From: Philip Woolger [REDACTED]
Sent: 02 November 2020 16:32
To: Kathryn Welch <Kathryn.Welch@arun.gov.uk>
Subject: RE: 8 Fernhurst gardens.

-The porch is slightly too large, to be covered by PD rights the maximum allowance is 3m² and your proposal currently measures at 3.84m² can you adjust this on plans 010 and 003.

Drawing No.010
Date 27/09/20
Issue 02 NTS.
Dimensions And
Garage added

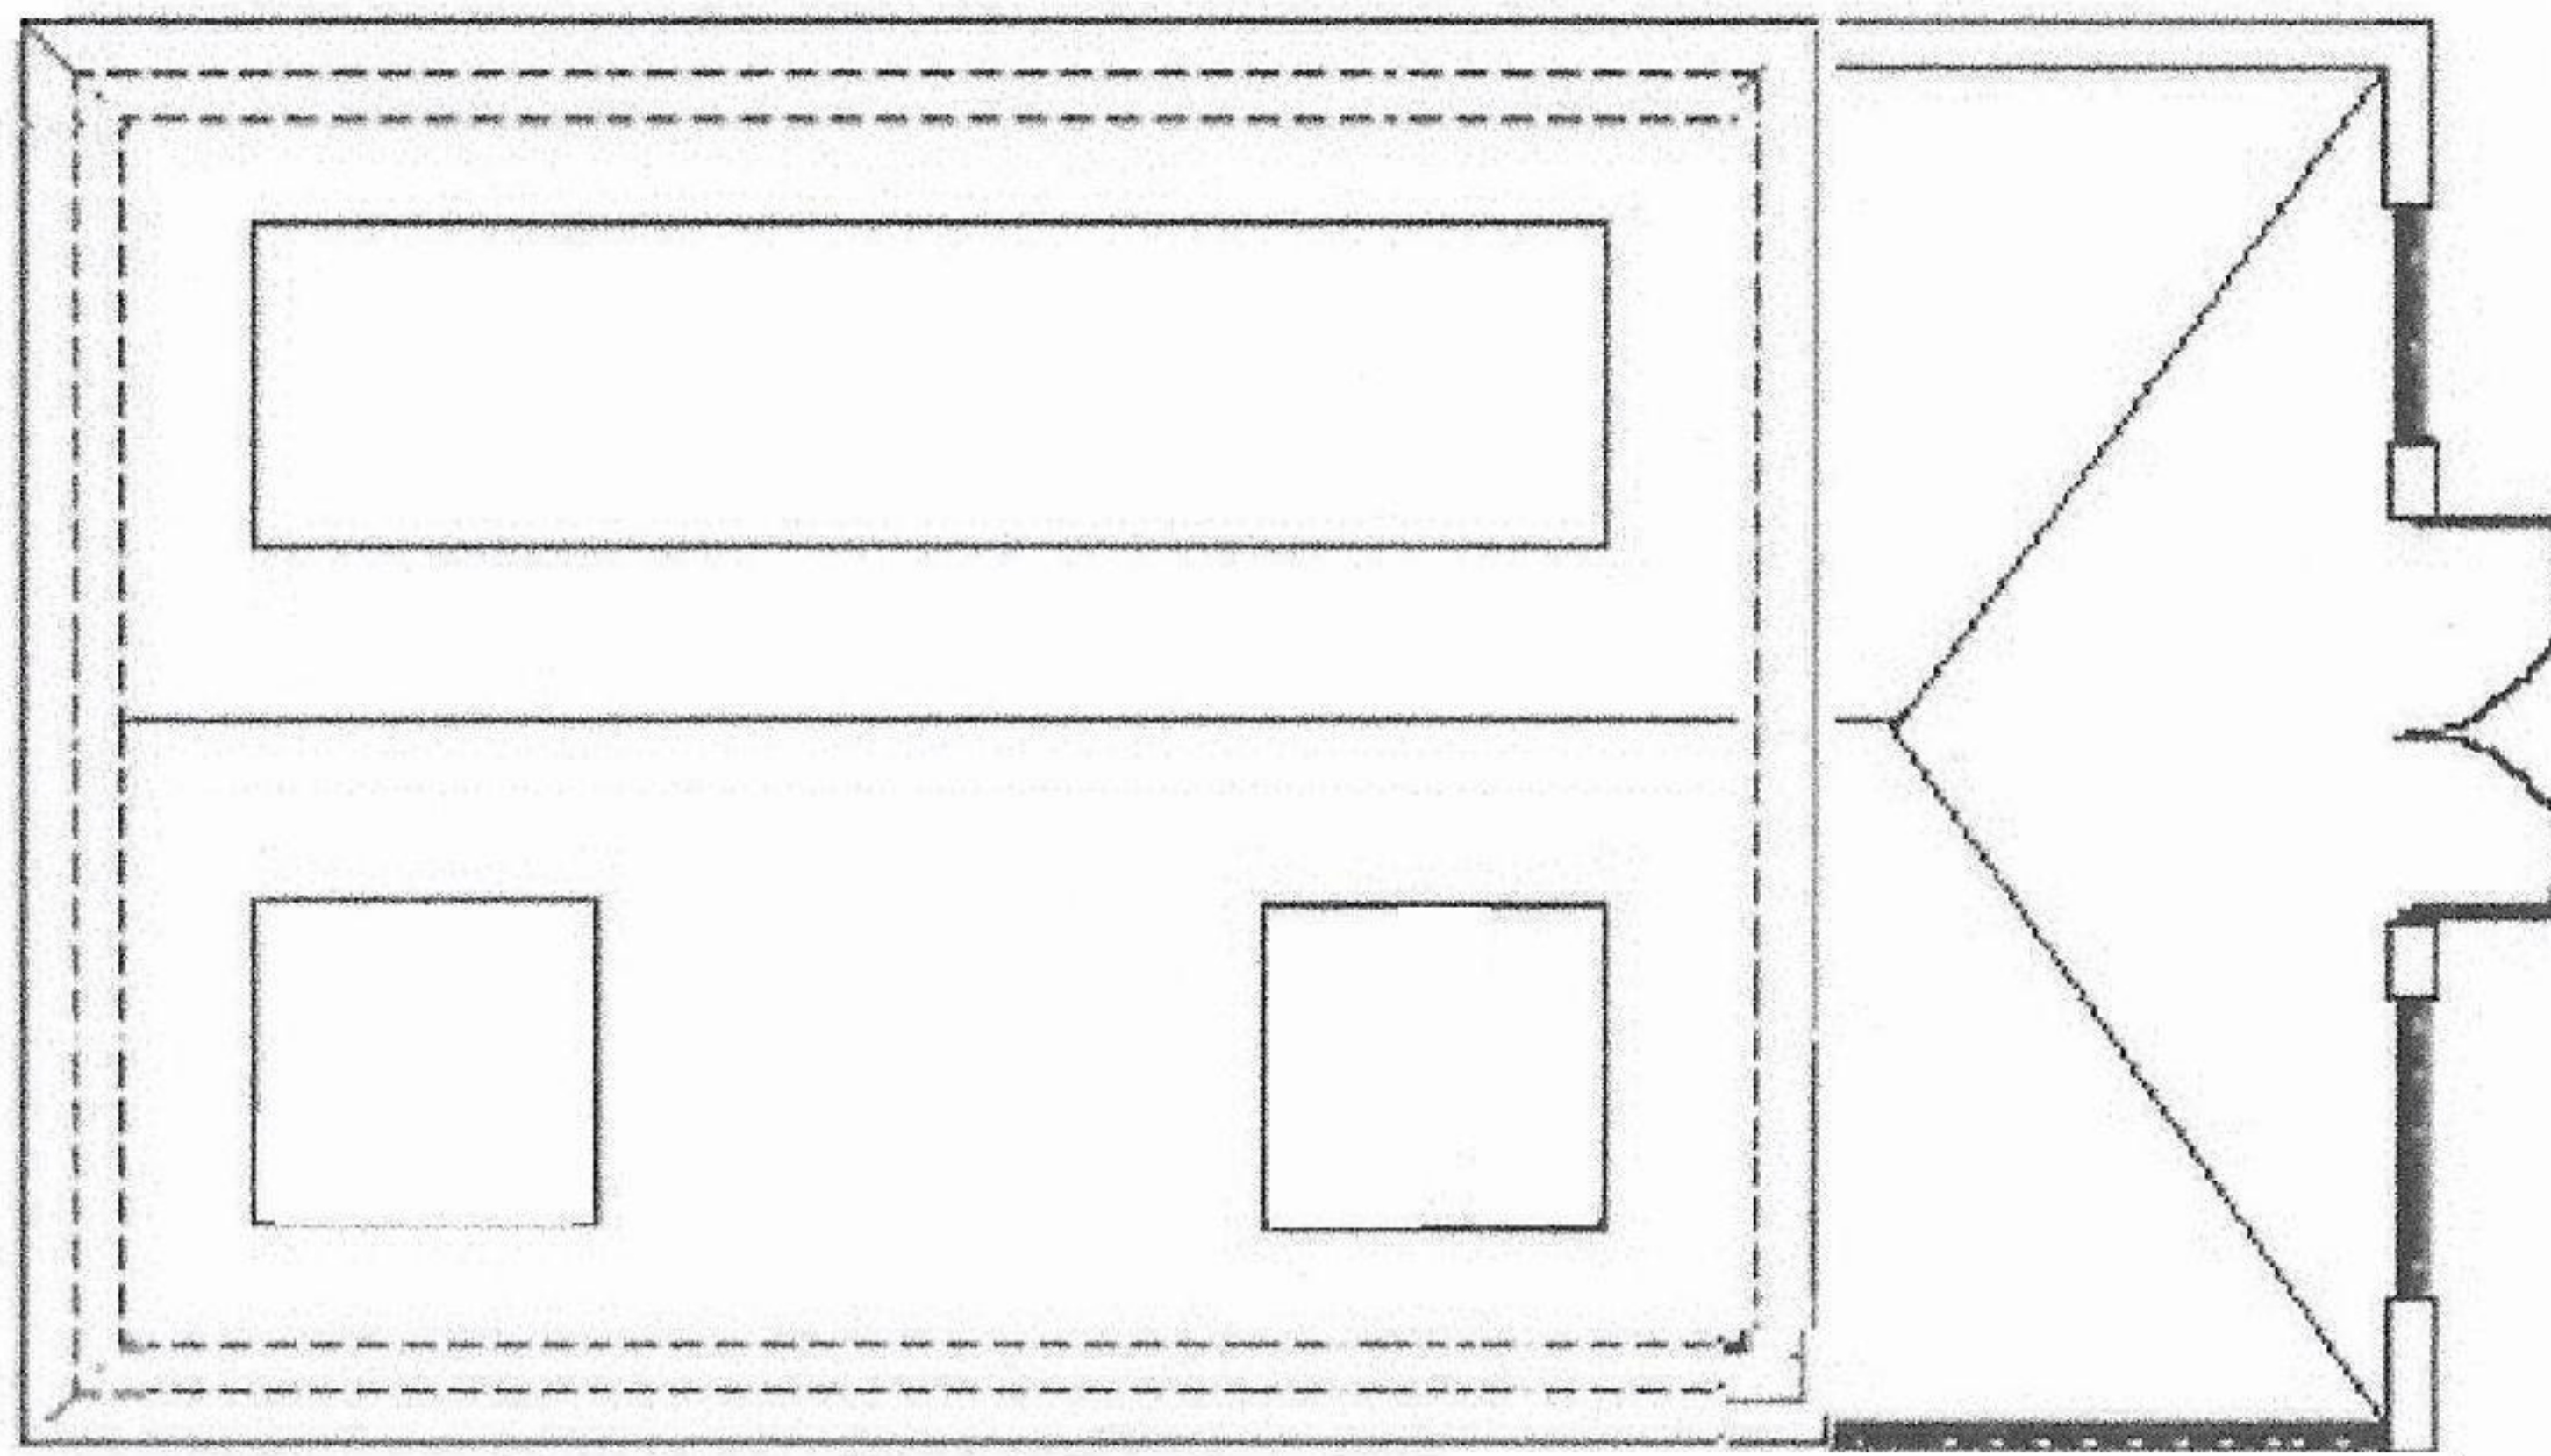
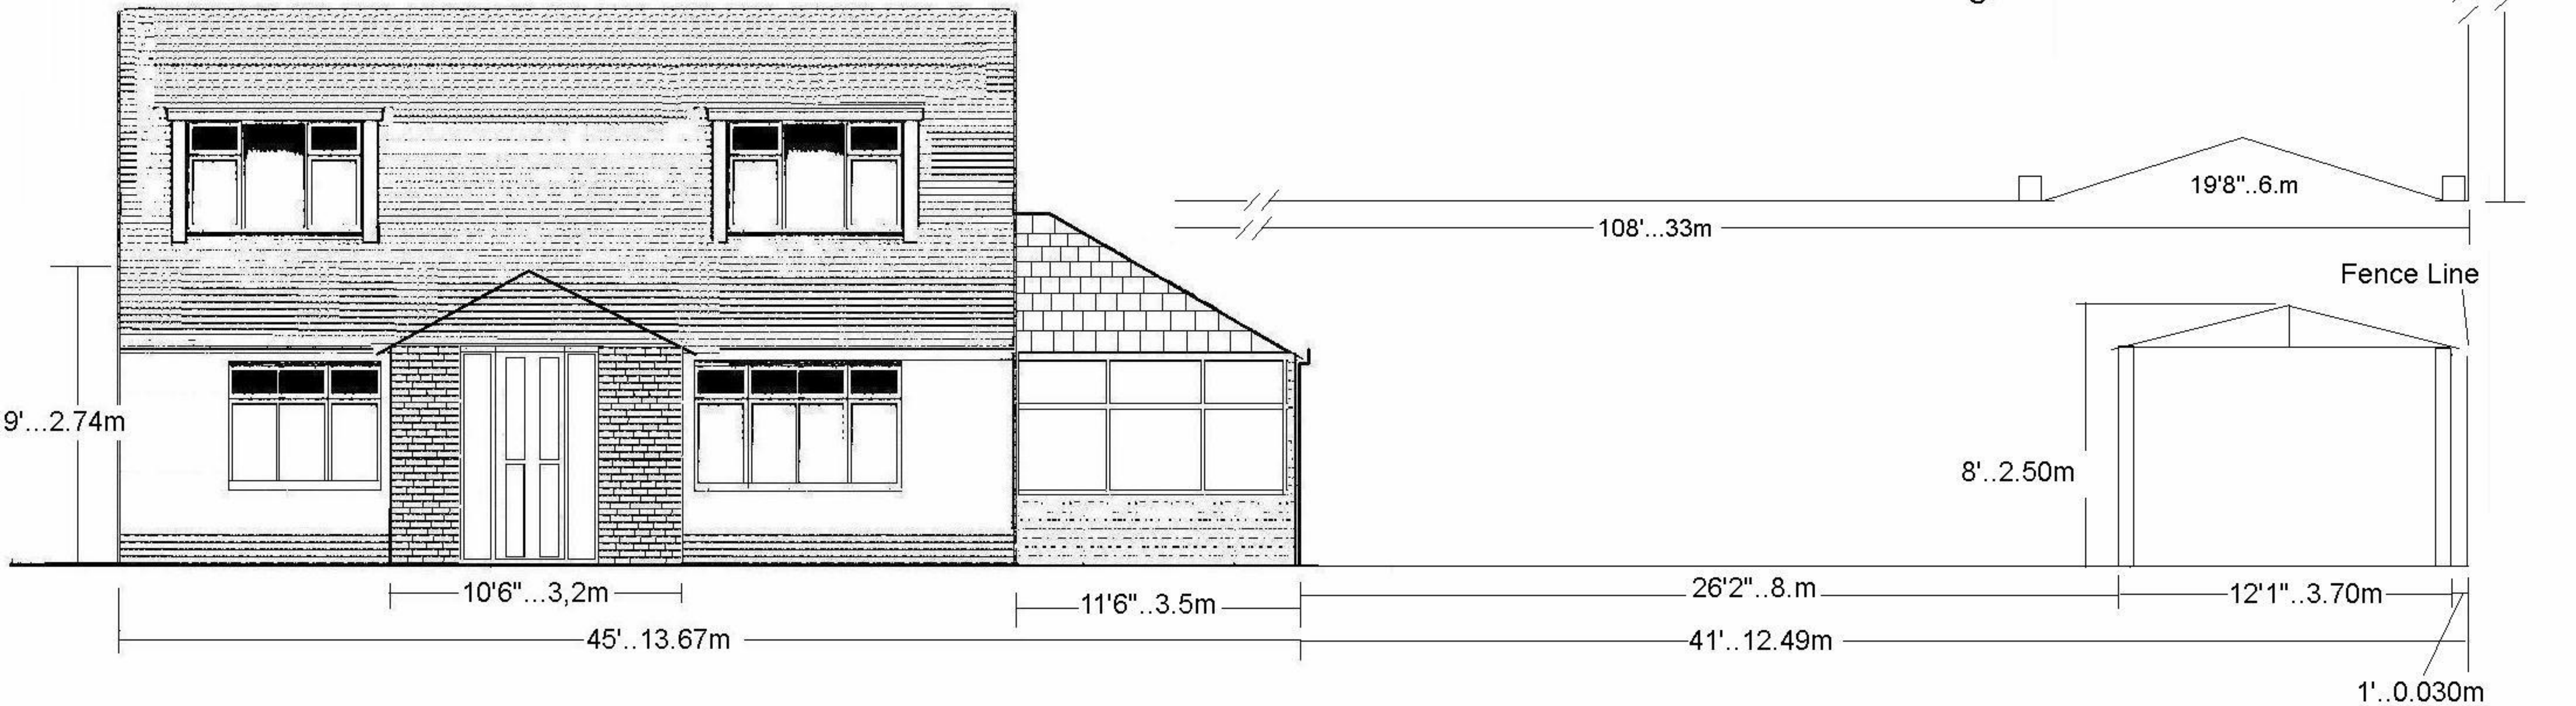
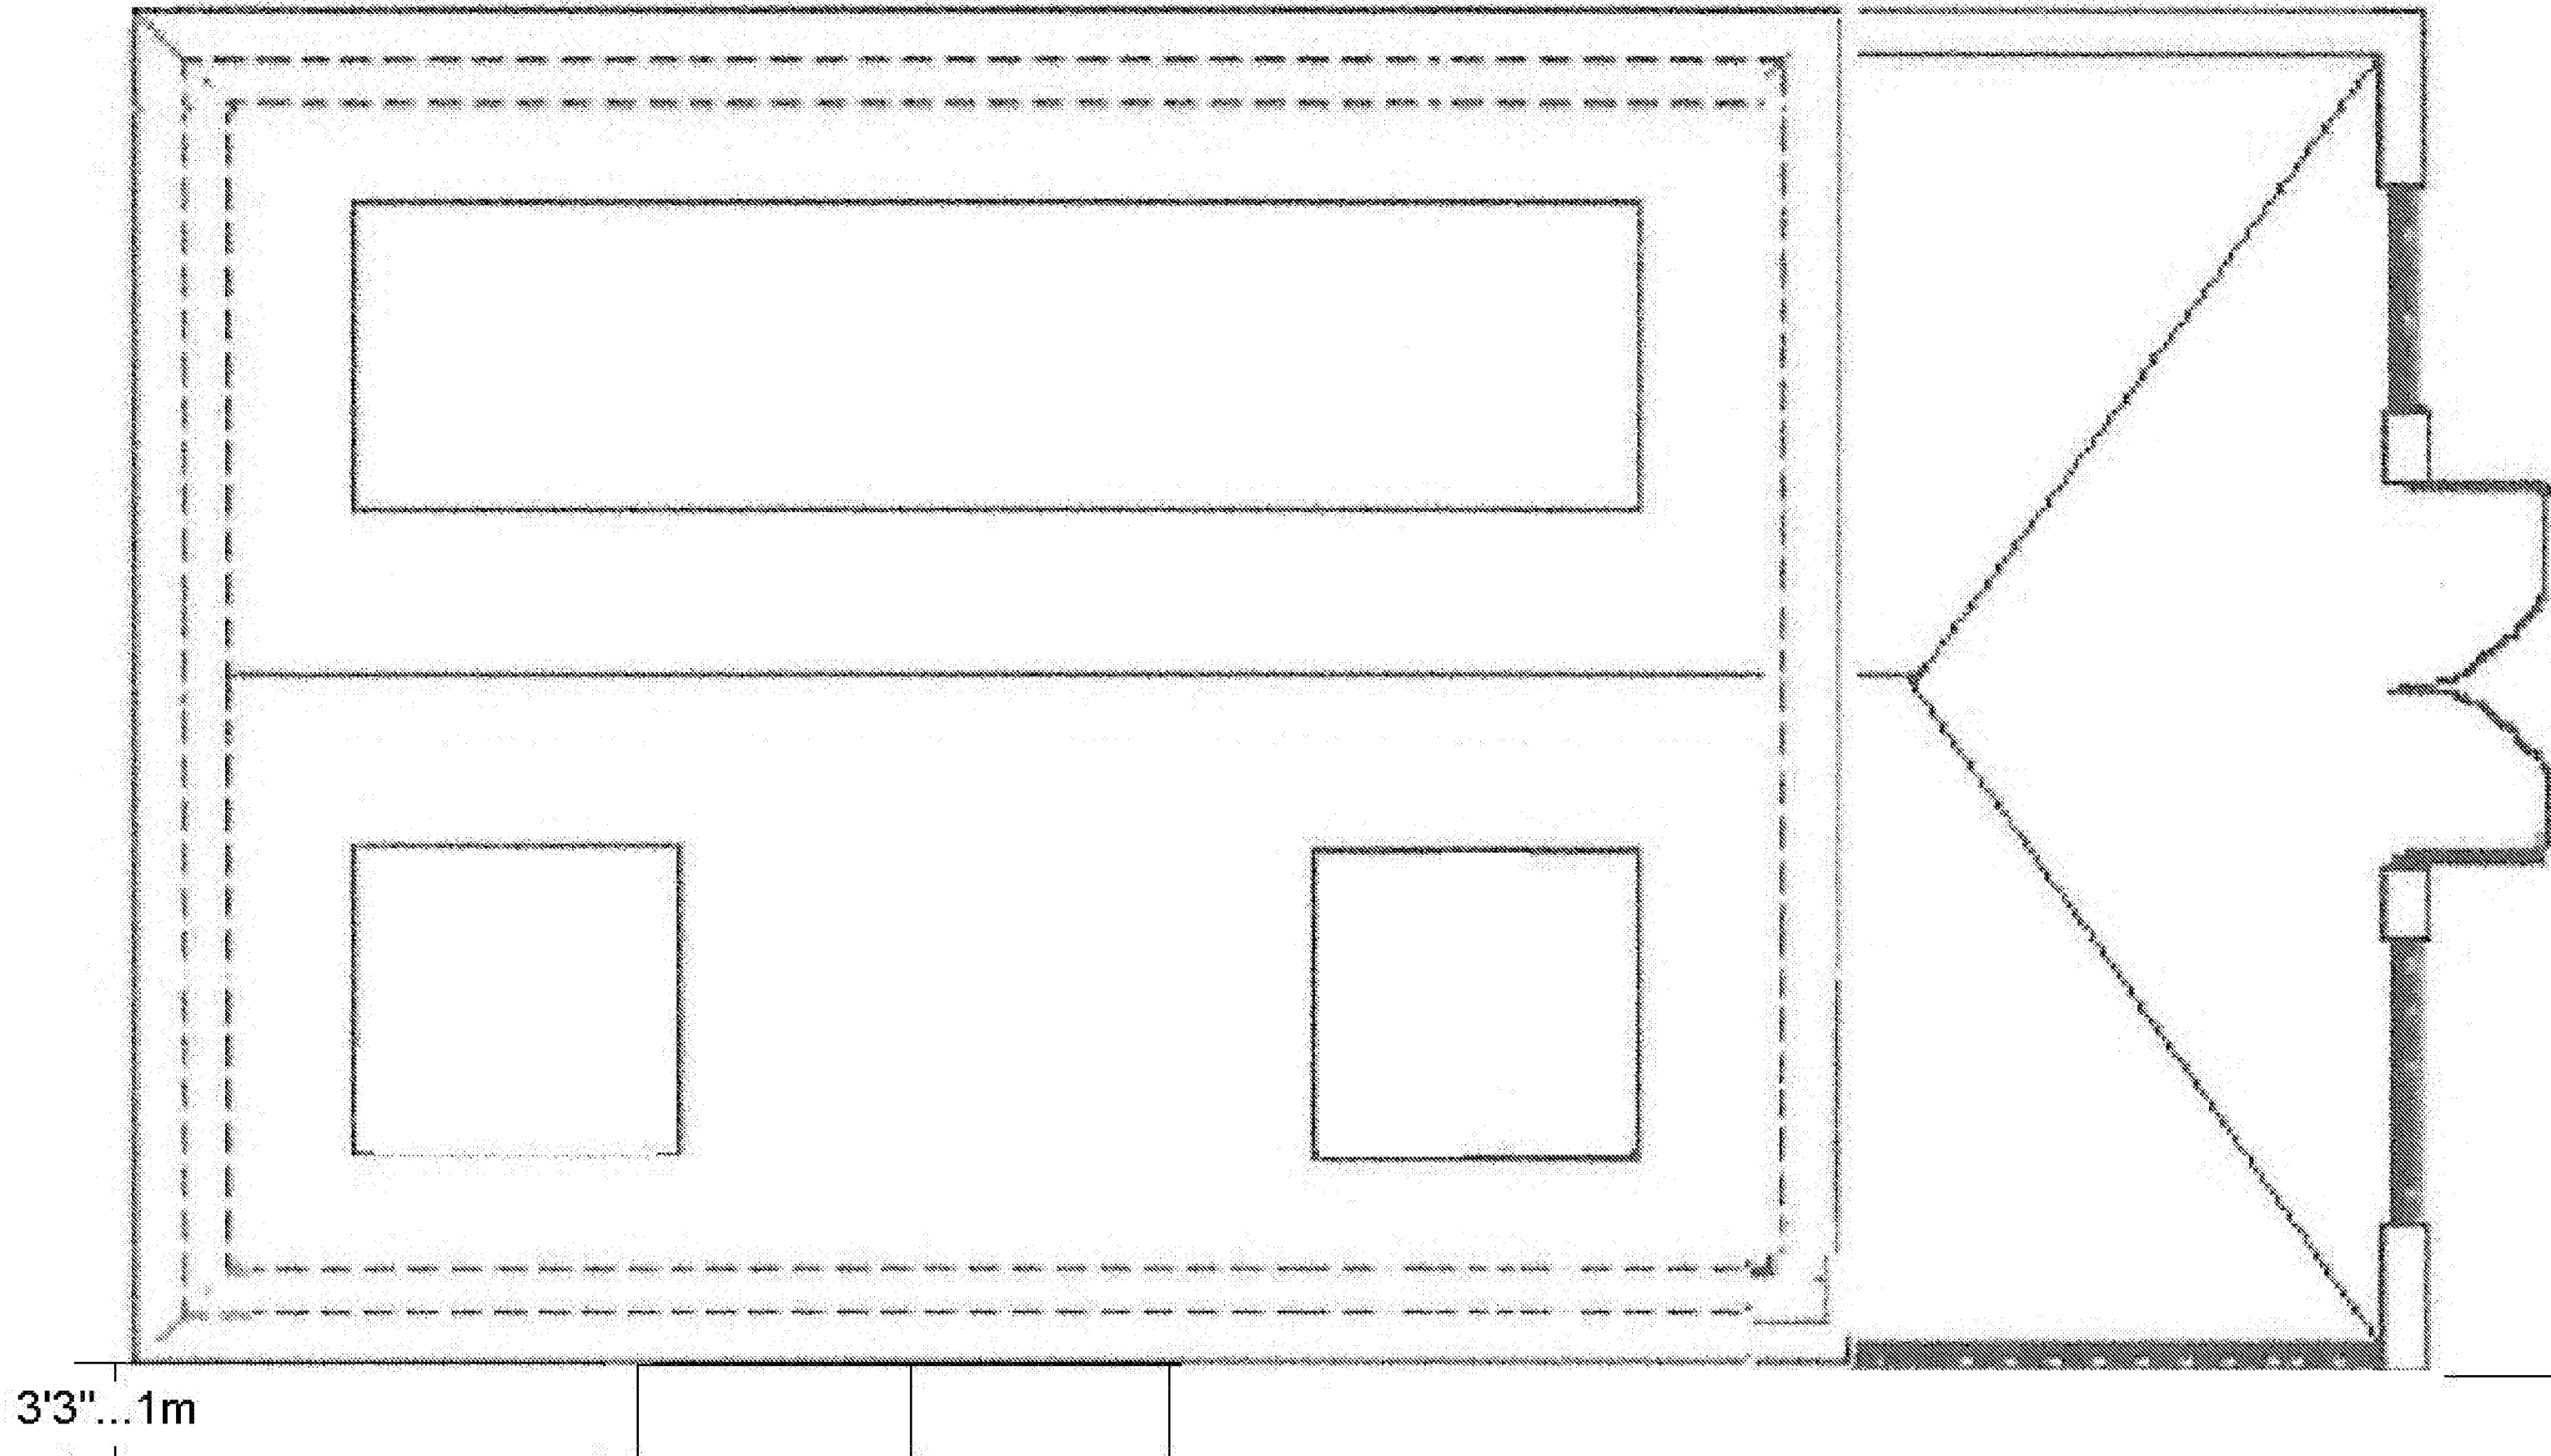
Can I get your permission to alter the description of the application, to include mention of the hardstanding in front of the garage please?

porch 3m x 1m ...2.2m to eaves.....Antique red Marley plain tile 265 x 165mm as per existing building.....and Block paved driveway (we were planning on this)just missed it off. We understand about the drain off on solid concrete.

Attached drawing 003...and 010...adjusted .
